Project #: 1009089 Application #: 12 DRB-70049
Project Name: Hunning Highlands
Agent: Campese, Steve Realty, Inc Phone #:

DEVELOPMENT REVIEW BOARD – SPEED MEMO

SITE PLAN FOR BUILDING PERMIT

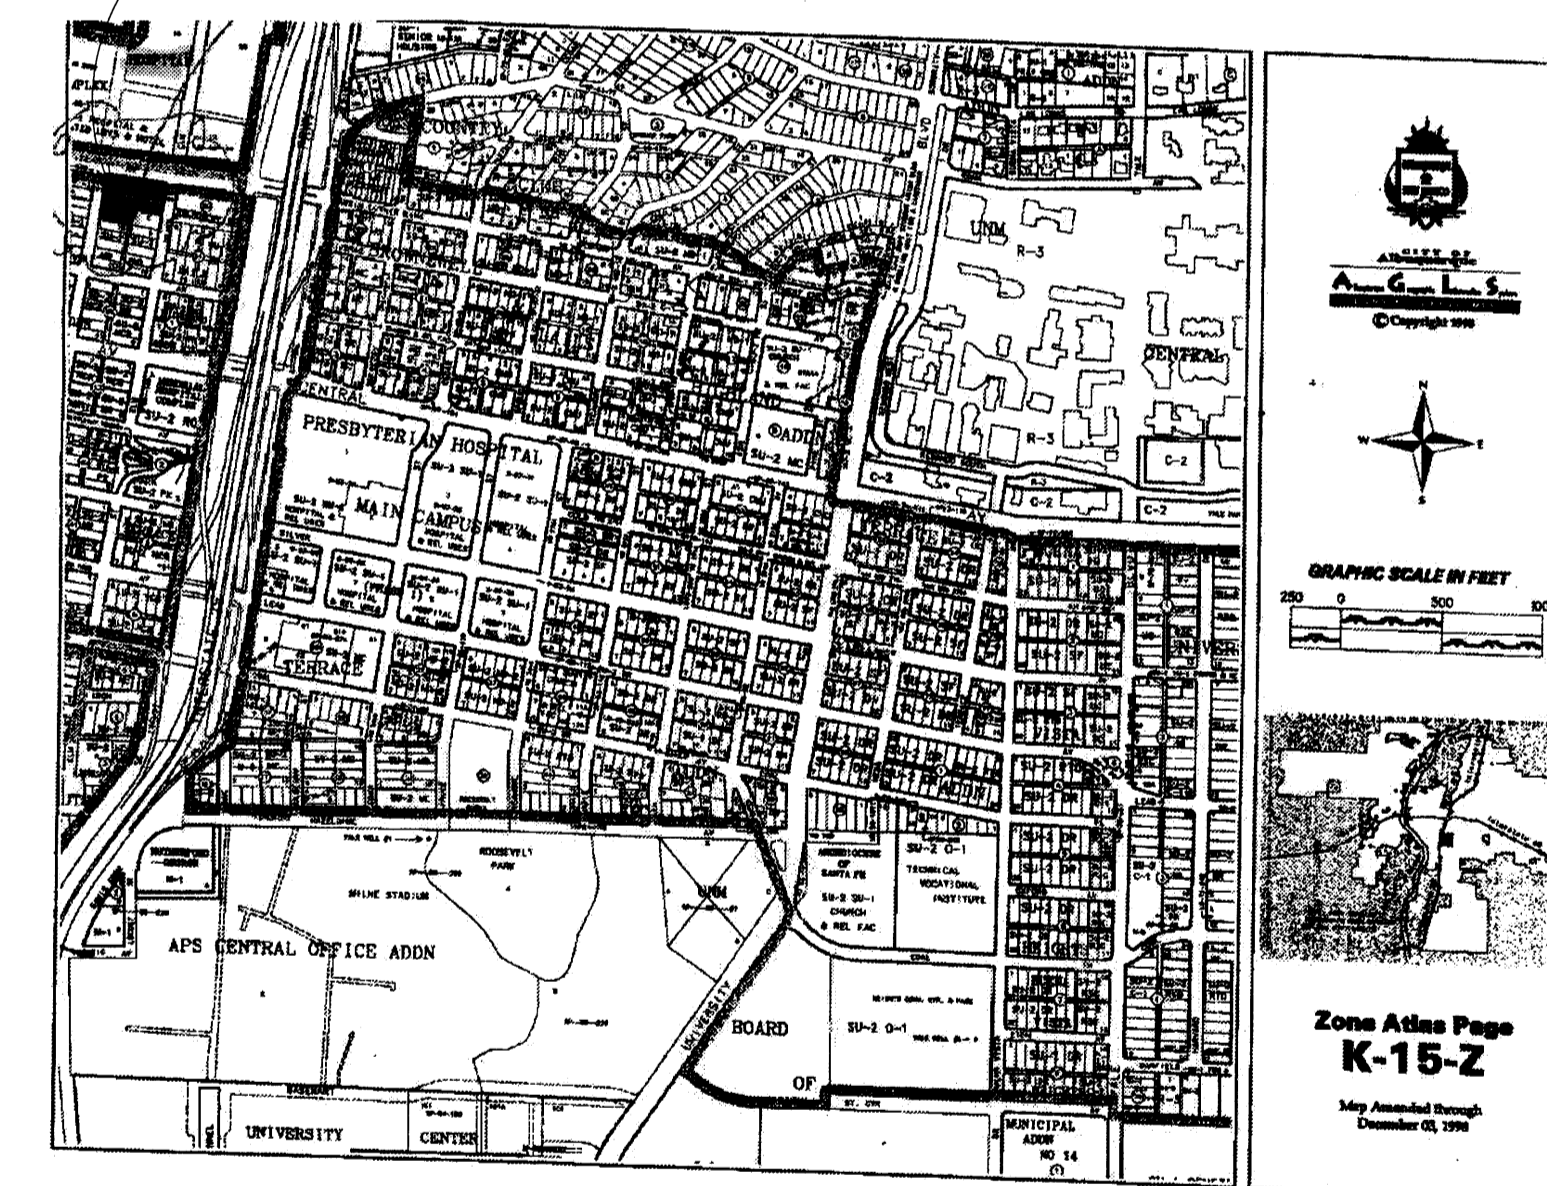
Please change words "trail access" to "bike lane"...along Martin Luther King Blvd on the Site Plan for Building Permit.

Provide an exhibit showing the location of sidewalk and defining the distance from face of curb to the property line. Right of way dedication may be required.

All easements must be shown.

Clarify how EPC Condition 4c (“A cross access easement and shared parking agreement are required between Tracts A and B, and a copy of the shared parking agreement will need to be provided at DRB for all tracts specific to specialty hospital parking use.”) is met. Provide recording information.

Sidewalk, a minimum of 6 feet in width, must be provided along Martin Luther King Boulevard.

What is the current status of the 16-foot wide alleyway? Has this alleyway been vacated?

Facility Signage at North Entry at Martin Luther King Boulevard

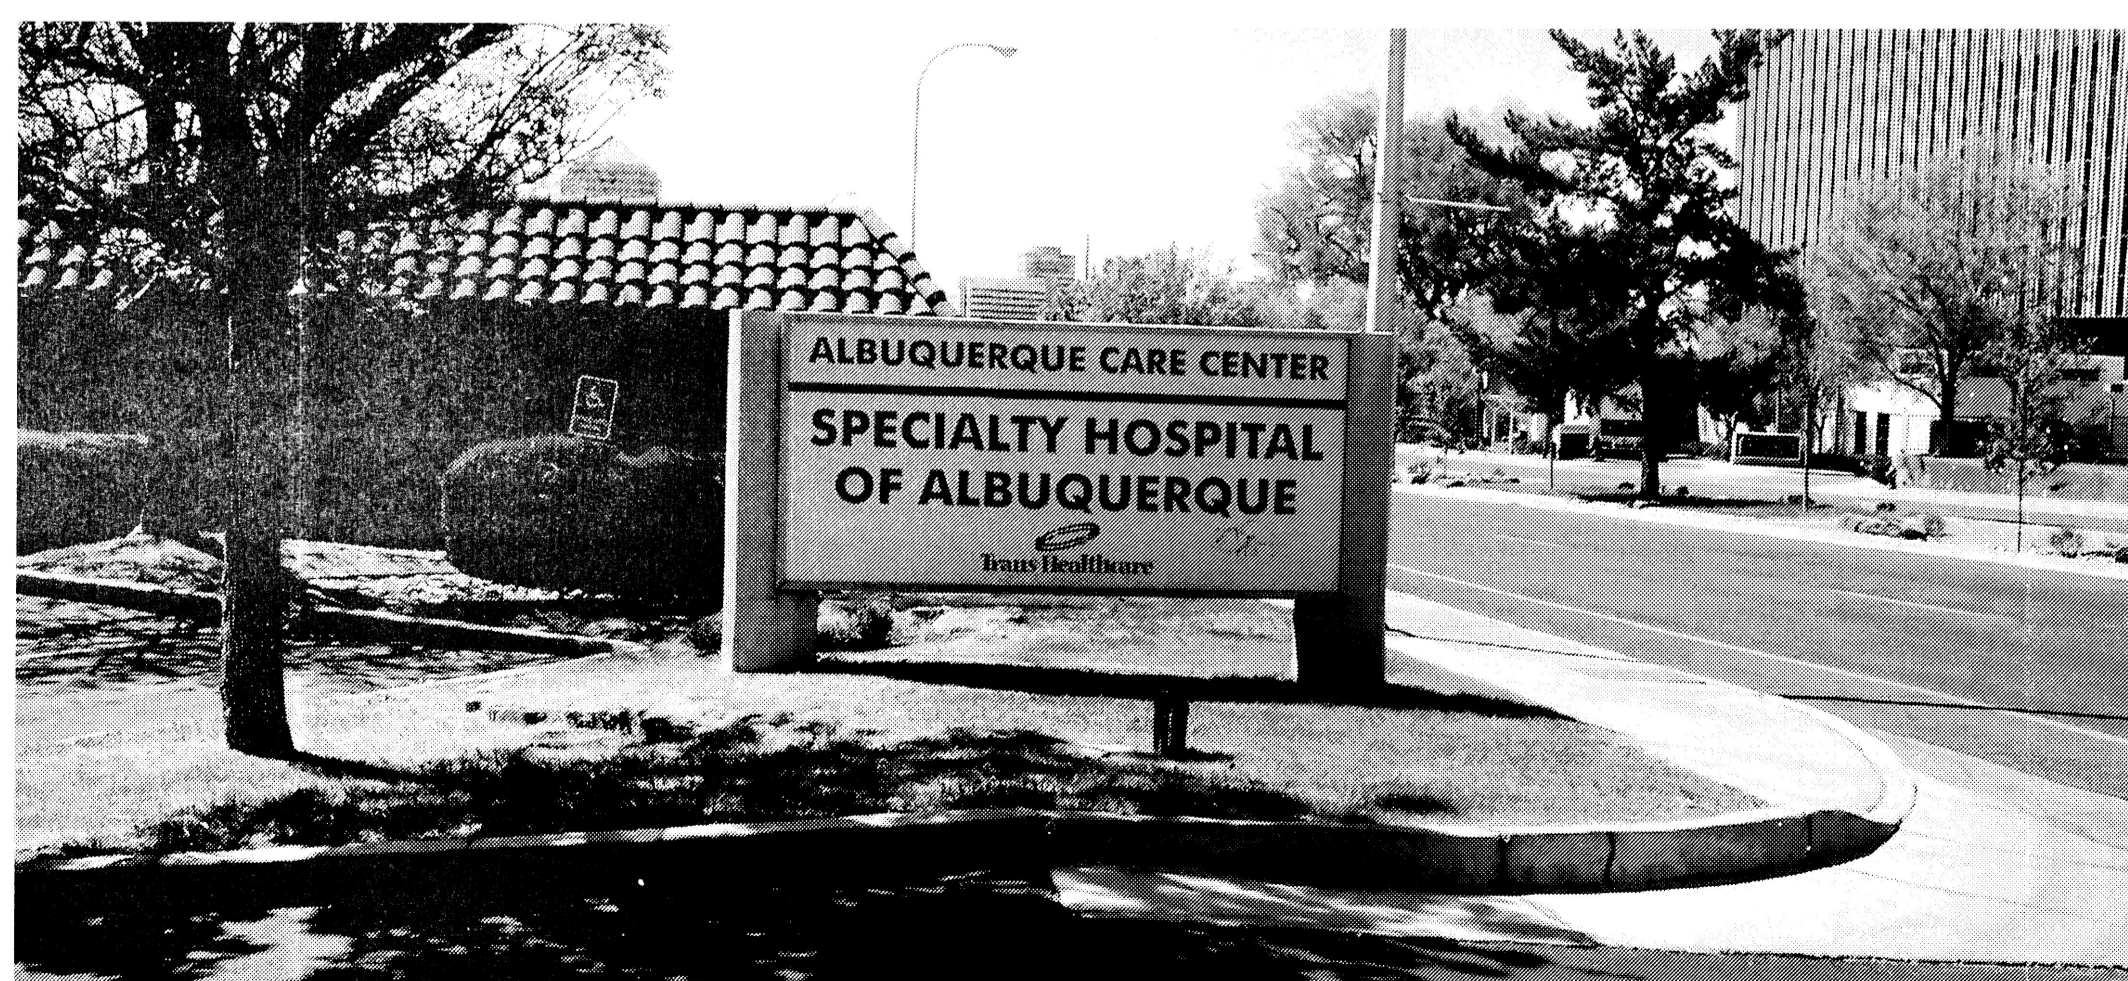
The proposed monument sign may interfere with the sight distance of the entrance. Please provide a sight distance exhibit.
